DEVELOPMENT REVIEW BOARD
TRANSPORTATION DEVELOPMENT

DRB Project Number: 1007489
West Route 66 Addition 2

SUBJECT: Preliminary/ Final Plat, Vacation Of Private Easements

**Development Review Board (DRB)
 Review Comments
 Utility Development Section
 Reviewer: Jon Ertsgaard, P.E.
 Phone: 505.289.3028**

SHEET 1 OF 3

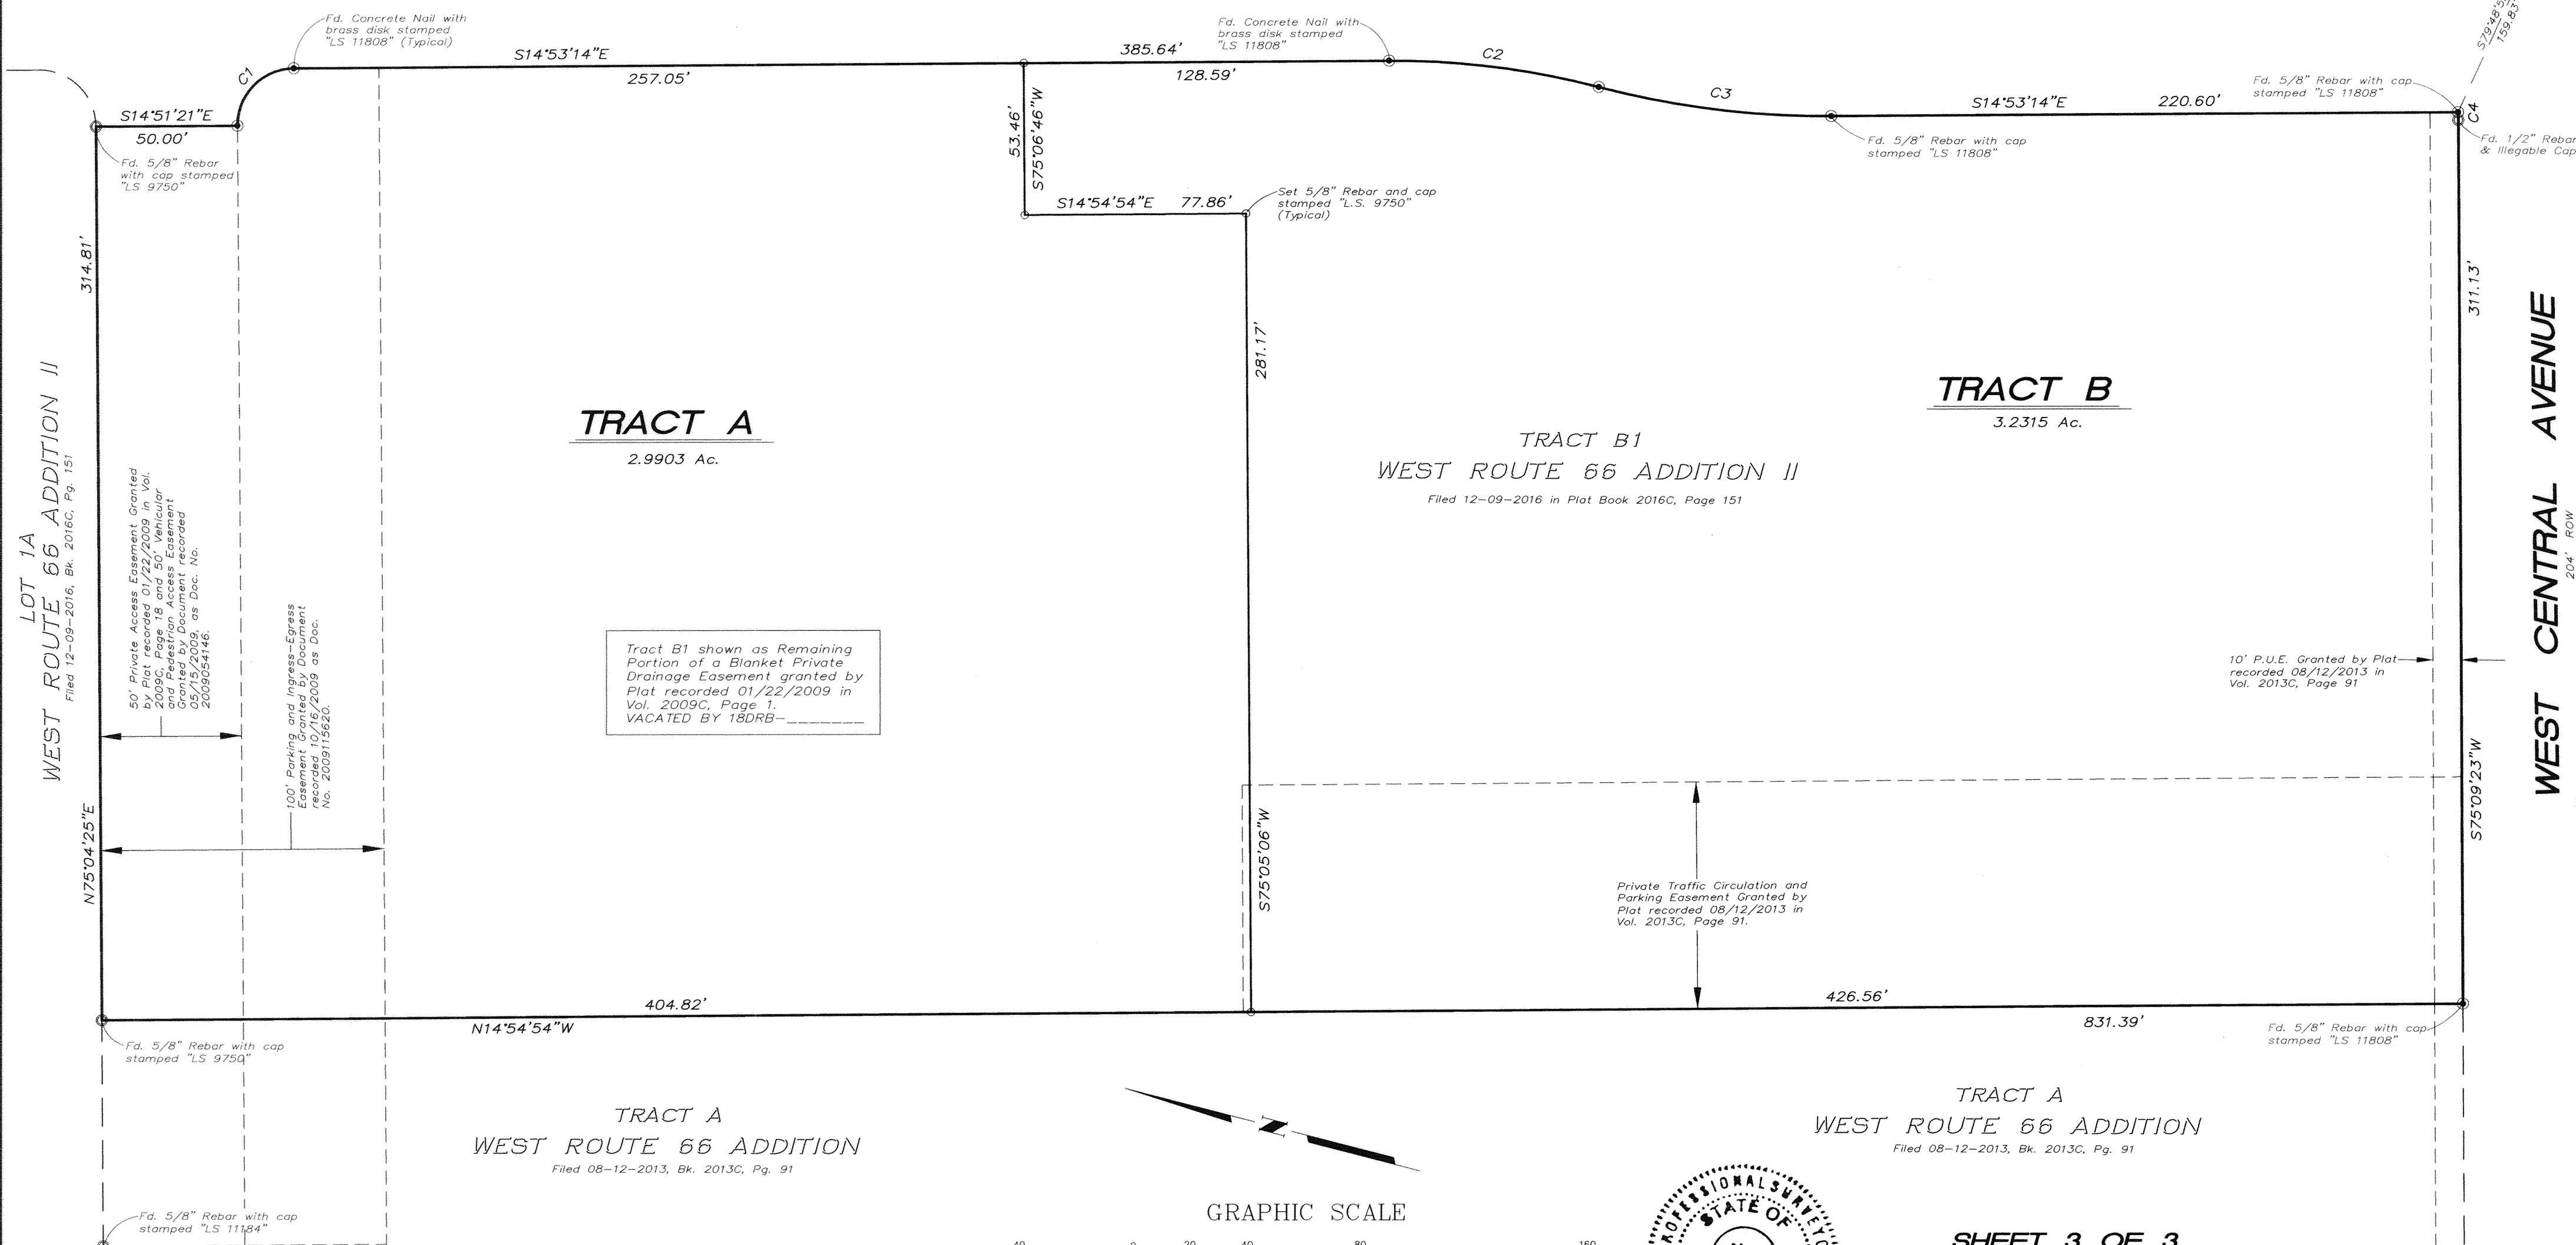
1. Verify where this development is located. The site plan is unclear, it should include the entire property.
2. The driveways located along Unser need to be closed.
3. For final plat, any access easements need to be shown with all beneficiaries and maintenance responsibilities listed.
4. Provide a sidewalk exhibit showing the location, width, and defining the distance from back of curb to the property line. Right of way dedication may be required.
